RE: 6/2019/2130/COND – Chequersfield, Welwyn Garden City, AL7 4TX

Thank you for consulting us on the above application for the submission of details pursuant to conditions 1(Land Contamination) 3(Materials) 4(Acoustic) 7(Surface water drainage scheme) 9 (Cycle Parking) 10 (Refuse and Recycling) 16 (External Lighting) on planning application 6/2018/1519/MAJ, at Chequersfield, Welwyn Garden City, AL7 4TX.

We advise the LPA that the information submitted in support of condition 7 in relation to surface water does not comply with the requirements set out in condition 7. Therefore, we recommend to the LPA not to discharge condition 7.

SA03

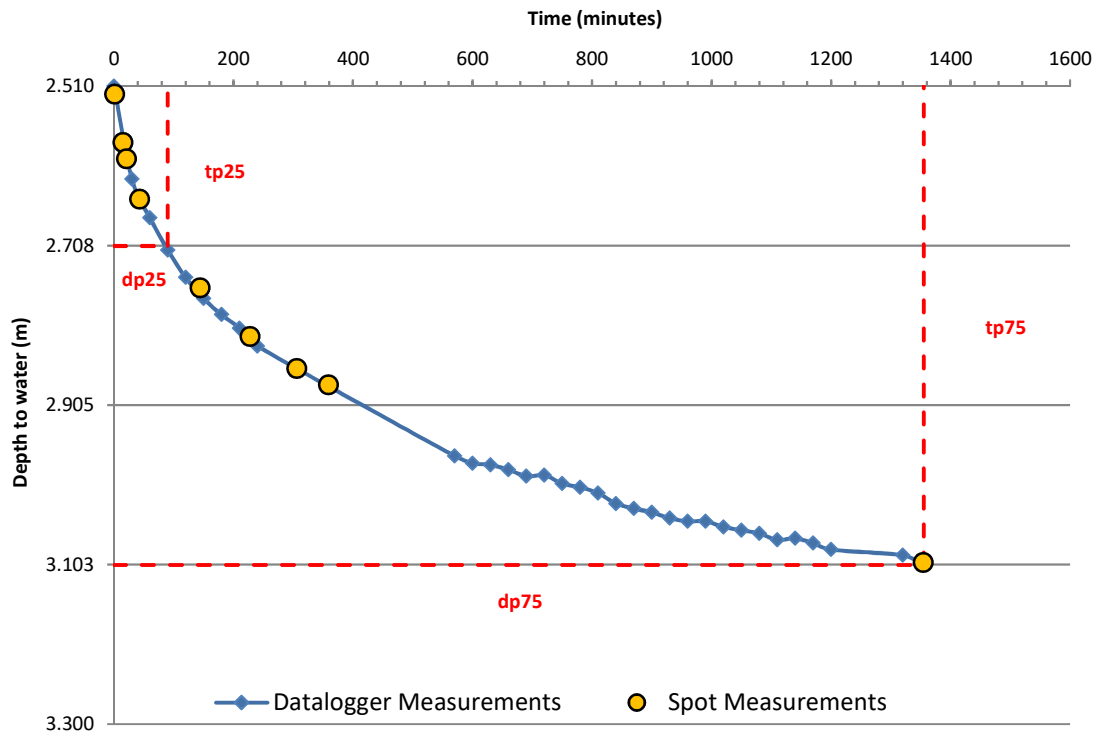
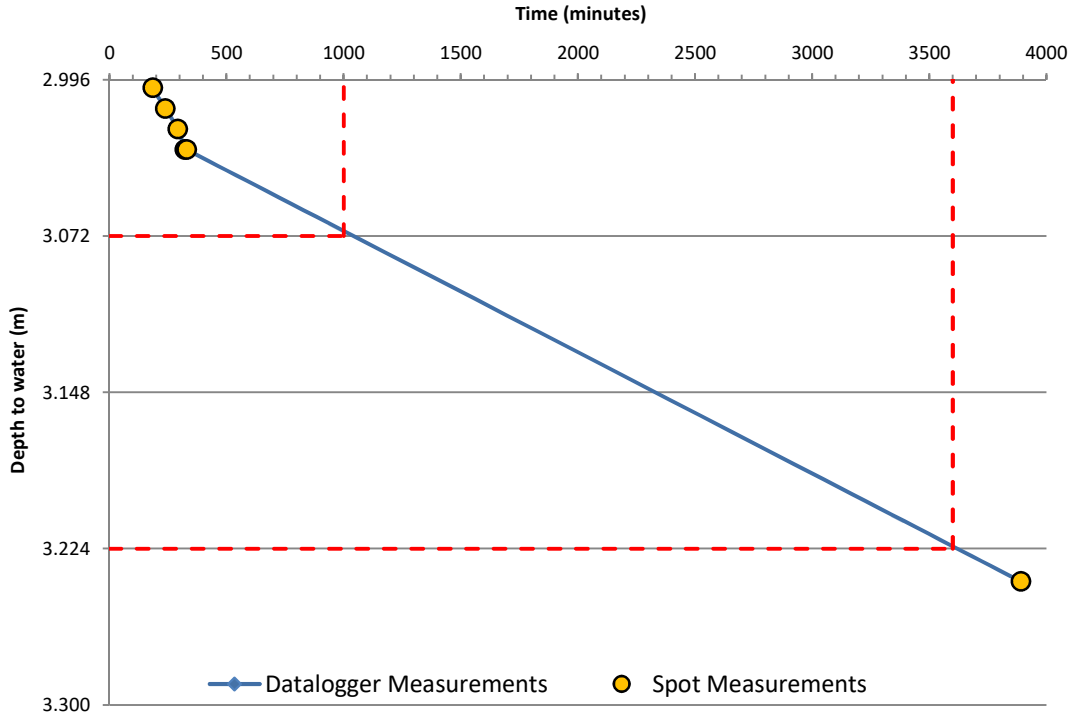
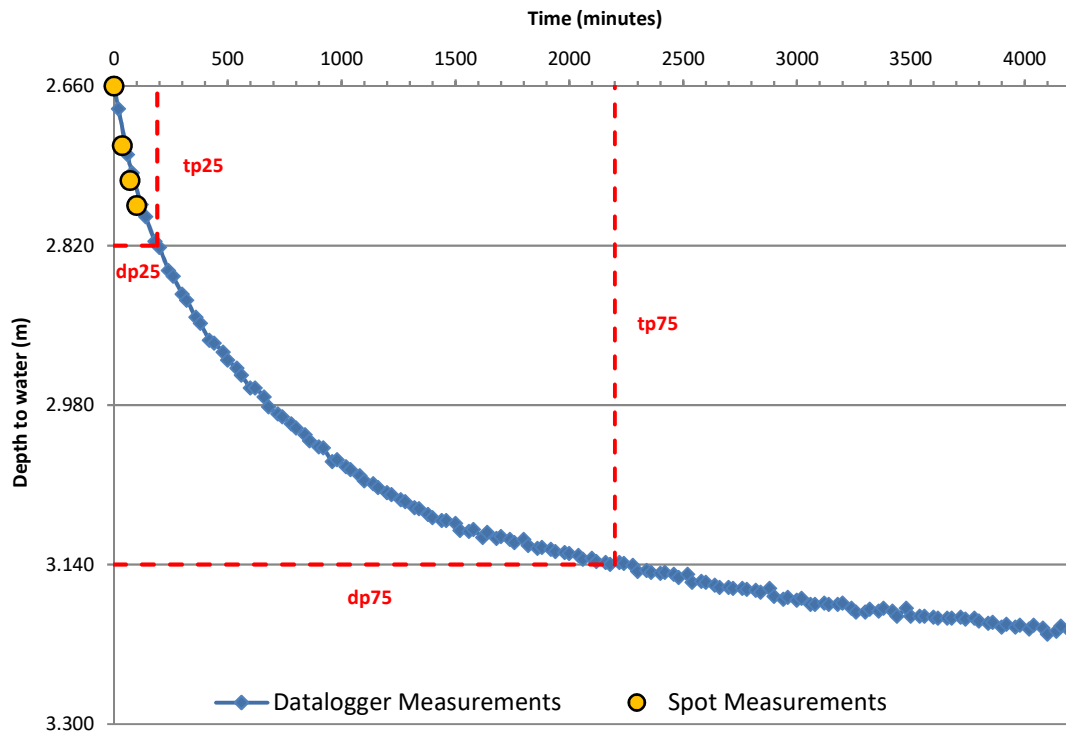
As soakaway 3 is designed with its depth being 3.9 m, we would consider this to be a deep bore soakaway. The development site lies within Source Protection Zone 3. As mentioned above, there is a risk of contamination at this location. Therefore, we would strongly advise that the Environment Agency should be consulted on suitability of a deep bore soakaway at this location.

As the LLFA, we would consider soakaway 3 to be a deep bore soakaway. The development site lies within Source Protection Zone 3. As mentioned above, there is a risk of contamination on site. Therefore, we would strongly advise the LPA that the Environment Agency should be consulted on suitability of a deep bore soakaway at this location.

Title
Plan showing existing site features and location of exploratory points

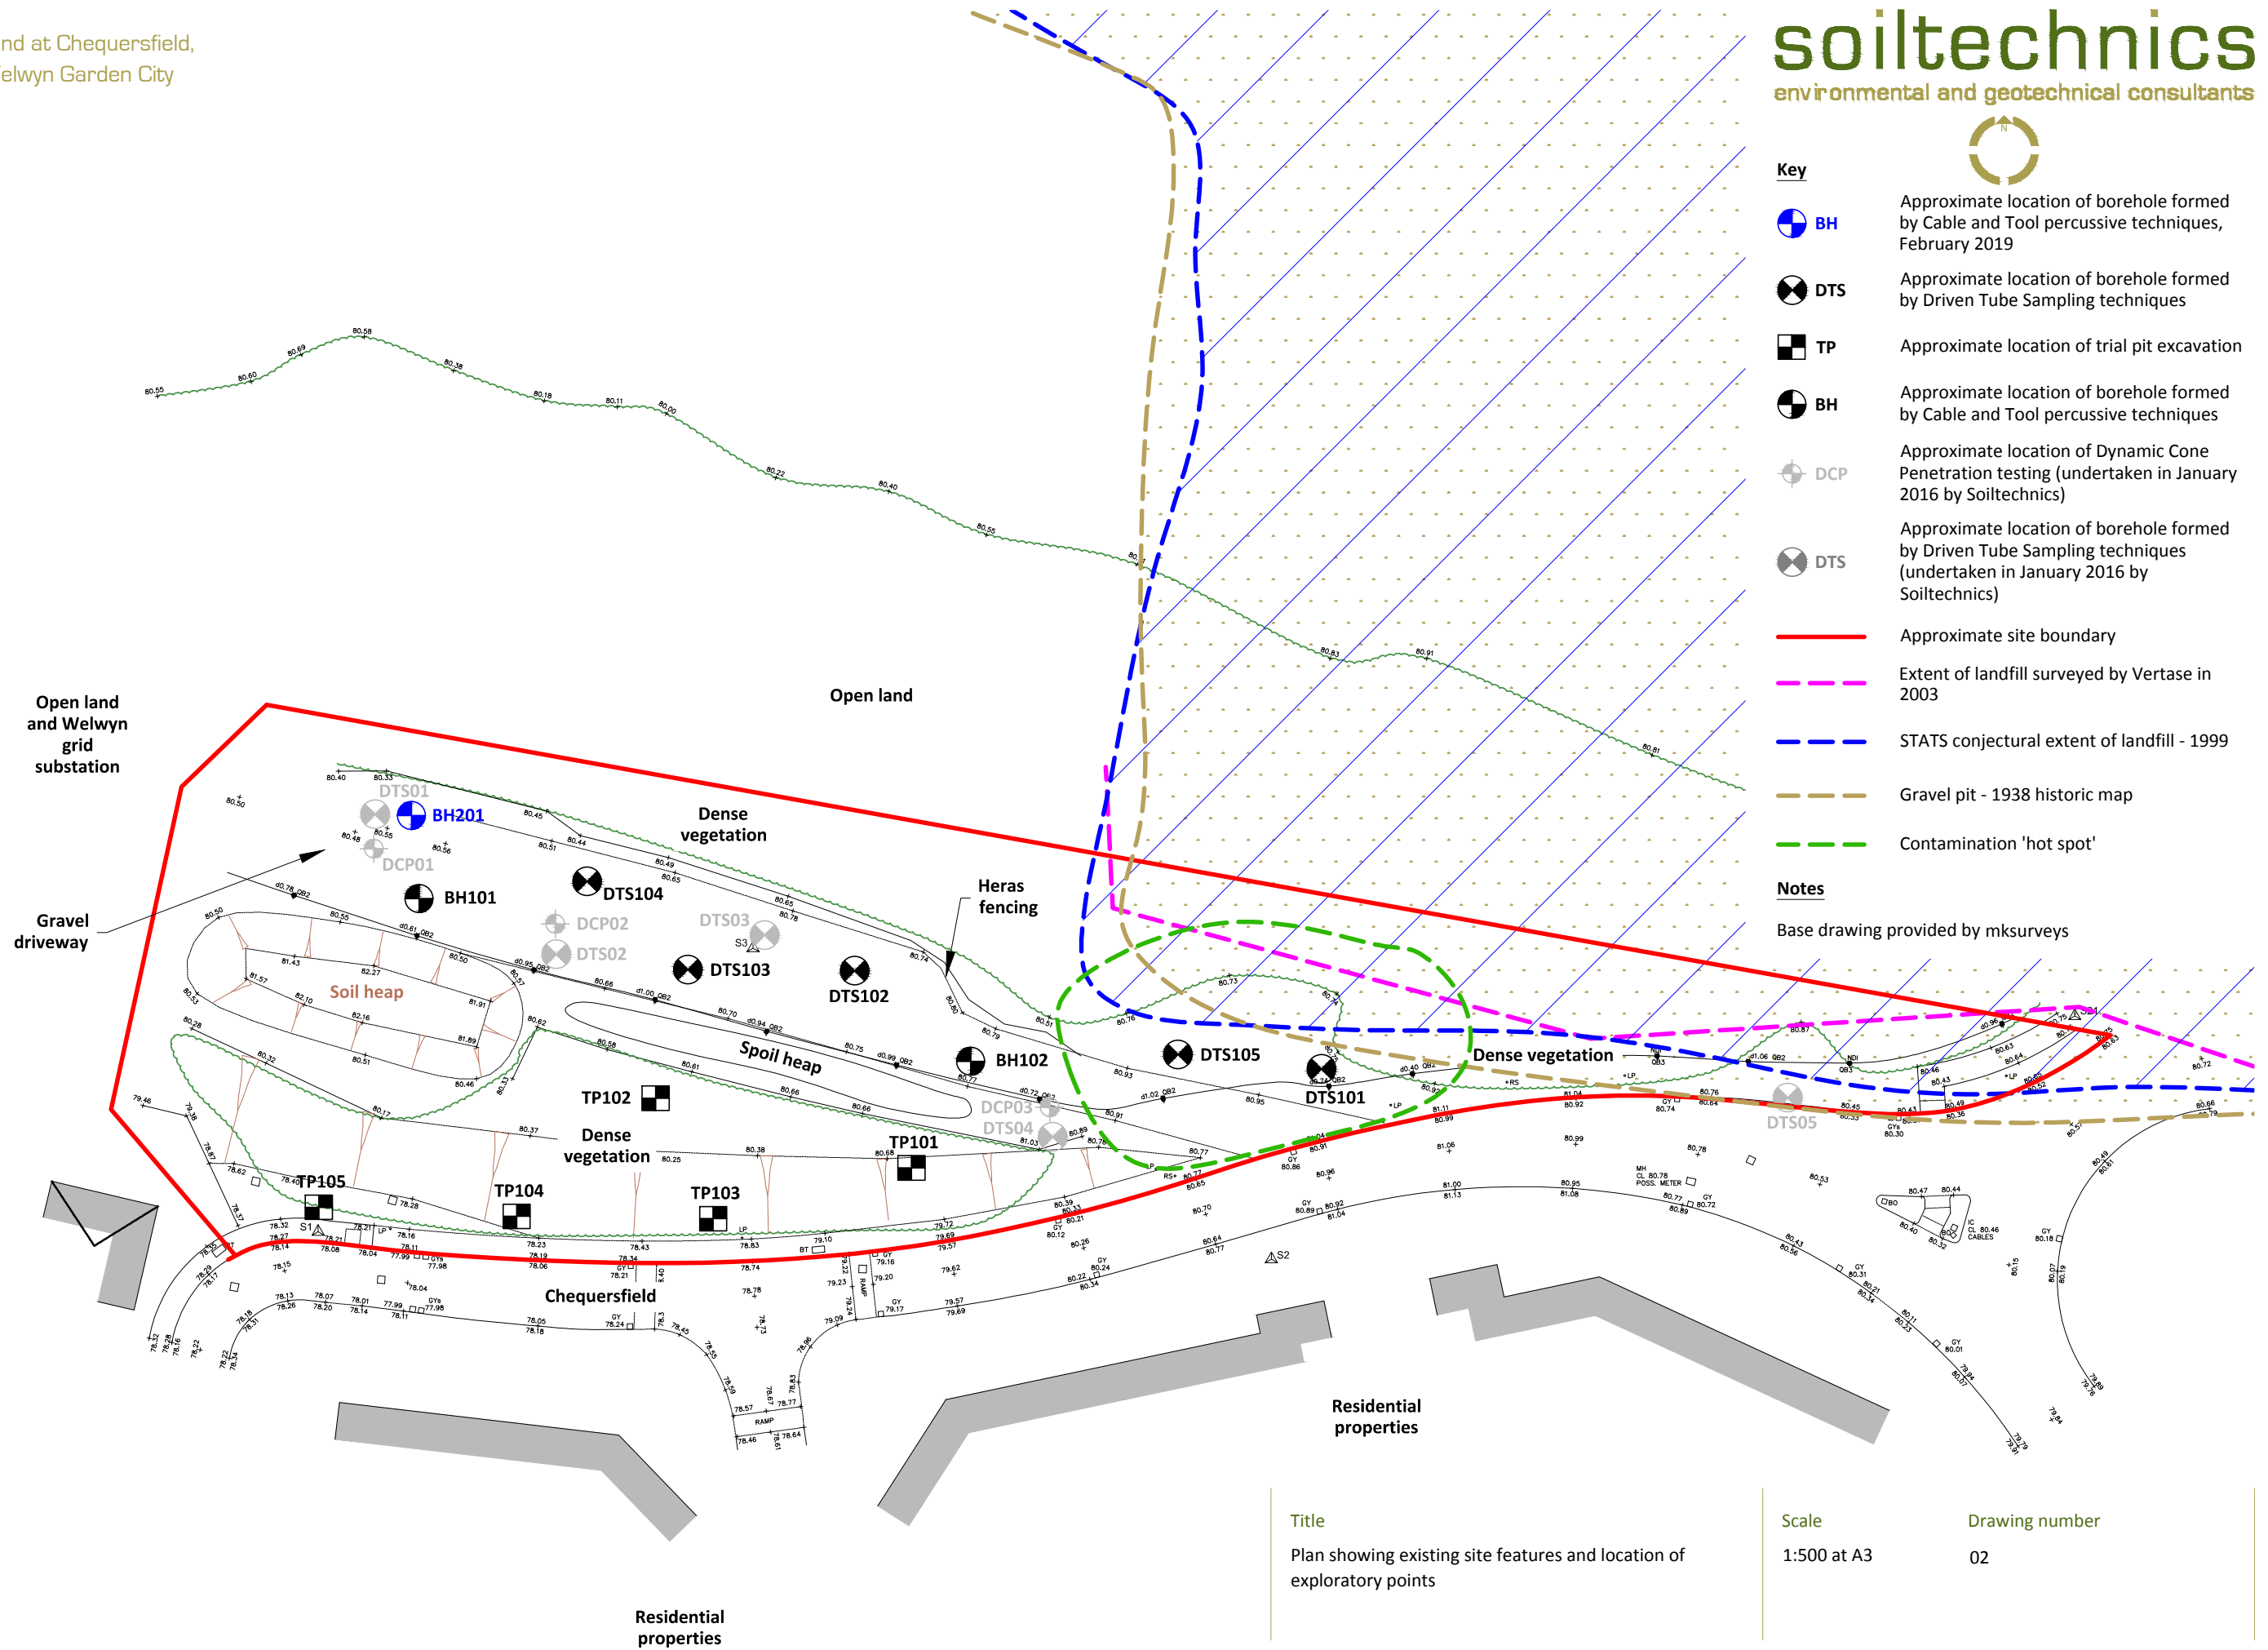
Moreover, based on the assessment of the Plan showing existing site features and location of exploratory points plan, we have noticed that a contamination hot spot has been identified at the location where soakaway 3 has been located. Therefore, we would strongly advise the applicant to clarify this.
